CITY OF PORTLAND, MAINE

Subject: Minutes of the Planning Board Meeting of Friday, October 10, 1969

45 Eastern Promenade
(Portland House)

Reference to the Portland House request for permit at 45 Eastern Promenade to provide a tenants lounge as per plan for tenants only on the first floor.

PROPOSED REVISION TO ADD
 ANOTHER MEANS OF EGRESS
 AT 1ST GARAGE LEVEL.

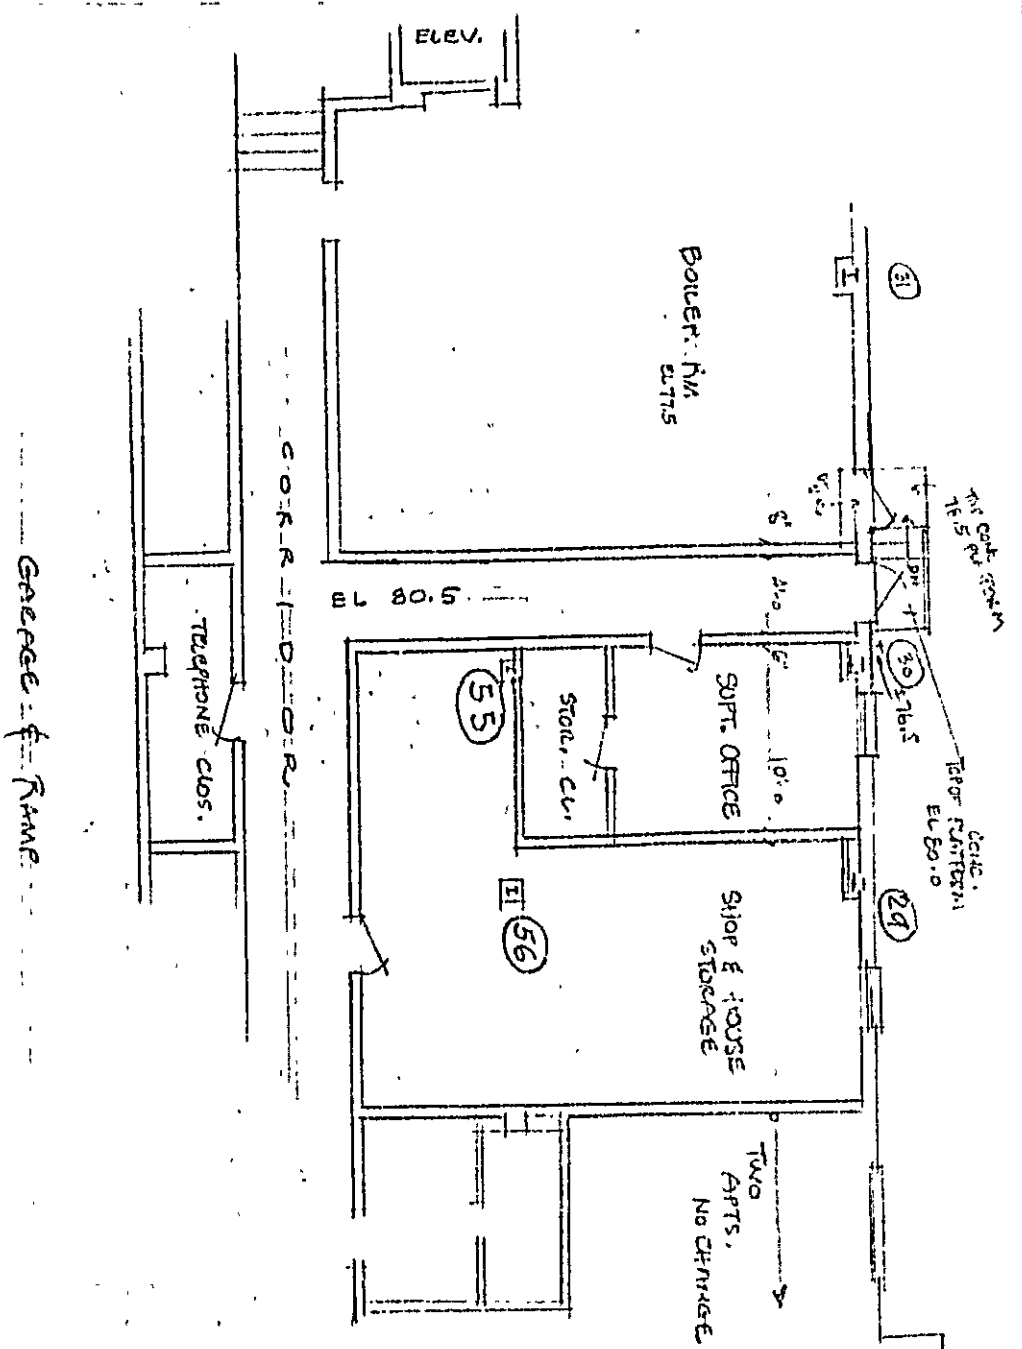
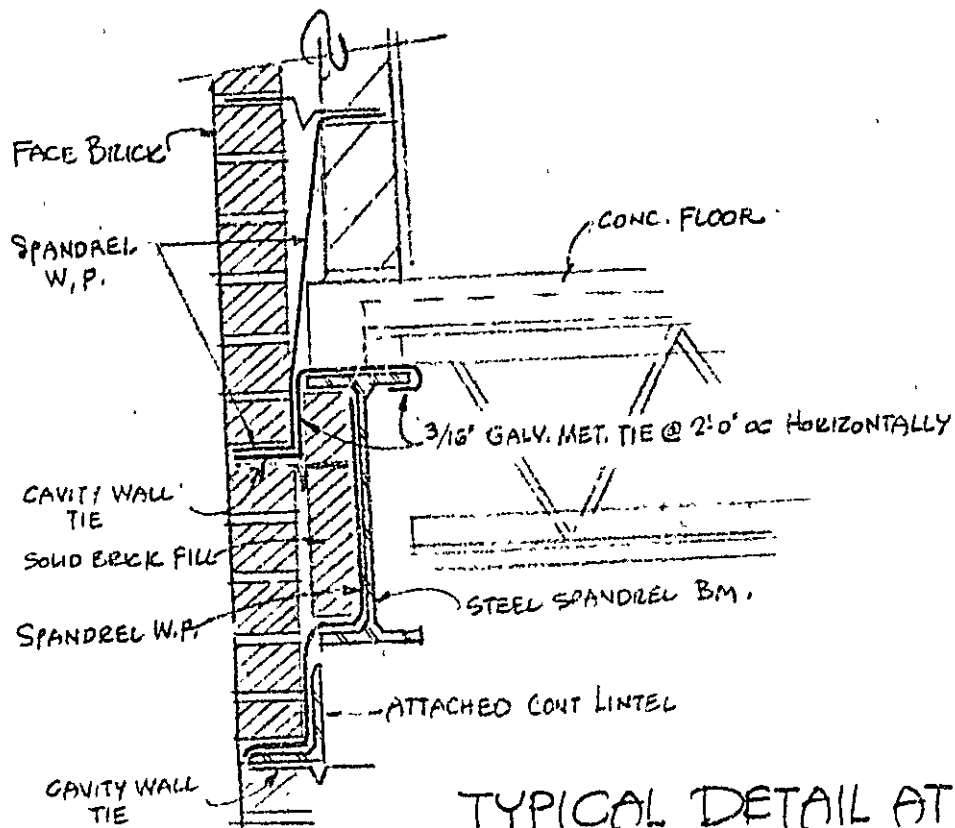
2. In order to comply with means of egress Section 402.5.1.4 stairwell Number 2 will need to extend from the first garage level to the second garage level so that in case of an emergency persons can go directly out-of-doors at the ground level. The extension of the stairway and passageway to the exterior door will need to be closed off from the garage by two hour fire rated walls and Glass 5 labeled doors with self closing devices. Any locking device on the exterior door will need to be of the vestibule latch set type. The function of this lock being that although locked from the outside can always be opened from within.

1. It is understood that you are to revise your plans to provide the second means of egress from stairwell number 2 more directly out-of-doors as per your revised print received December 18, 1967. This means of egress is to be lighted and marked with exit and directional signs which will need to be shown on your revised plans.
2. The Standard Corralux Pyro panels are acceptable for use as balcony dividers.
